18 January 2021

610.18552-L02-v0.2 RFI Acoustics.docx

Trinity Grammar School Renewal Project DPIE Request for Information - Acoustics

SLR Consulting has been engaged by Trinity Grammar School to provide acoustic design advice for the Renewal Project at Summer Hill Campus (SSD-10371).

Junior School Play

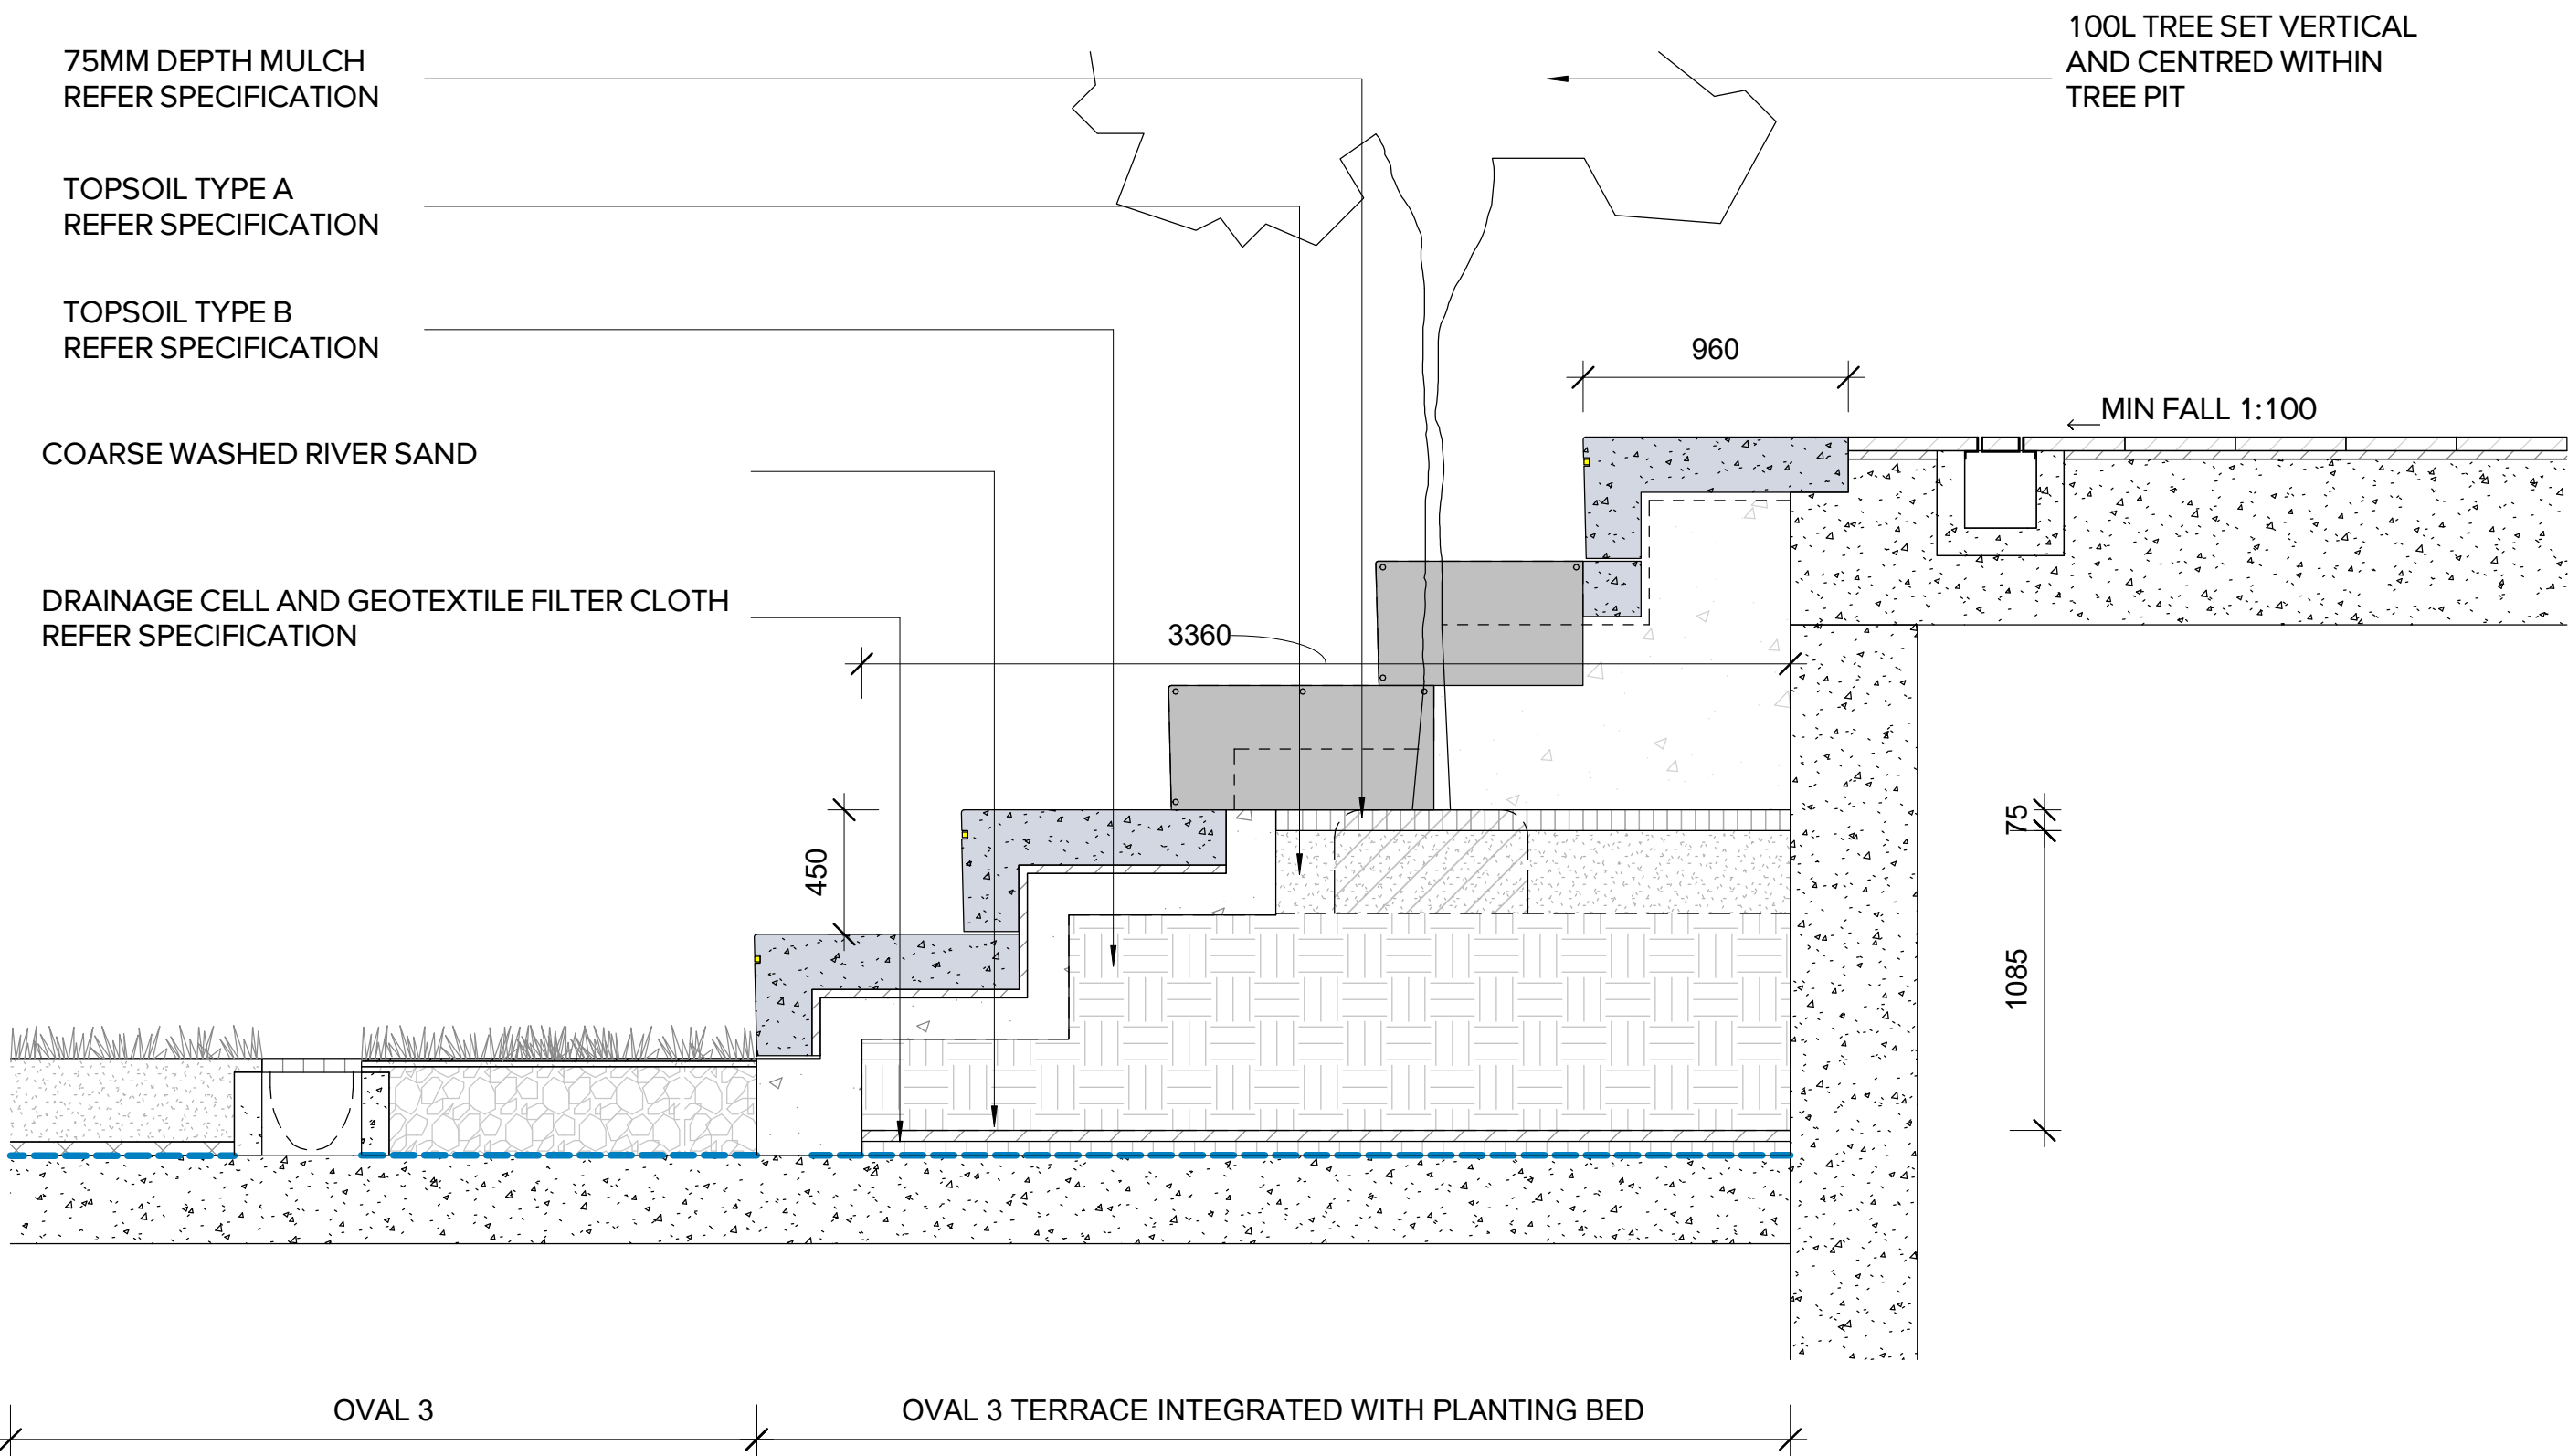
According, the Department requests that consideration should be given to measures to reduce the additional noise impacts of the proposal. The Department is not supportive of a further solid construction boundary fence to Seaview Street as it would result in associated streetscape and natural surveillance impacts, noting that a solid fence is already required for part of the frontage due to noise from the loading dock.

The new Junior School play area adjacent to Seaview St has been assessed separately based on the proposed use. Assumptions made for the assessment include:

Number of students	Play duration	Acoustic screening	Offset distance to nearest receiver	Predicted L_{Aeq} Receiver level (dB)	Noise Goal	Compliance?
80 students	< 2 hours	None	30 m	58	52	No
40 students	< 2 hours	None	30 m	55	52	No

The results in **Table 3** indicate that exceedances of 6 dB and 3 dB above the noise goal are predicted at the nearest receiver with 80 and 40 students, respectively. It is noted that the goals in the AAAC Guideline are not mandatory and where they are not achieved, then it does not necessarily follow that noise levels would result in unacceptable impacts at the surrounding receivers.

Based on the measured existing noise levels and the proposed activity being a feature of the area, the usage assumptions in **Table 3** are considered reasonable and appropriate mitigation measures. No further mitigation measures are considered necessary or reasonable for the reasons discussed above.
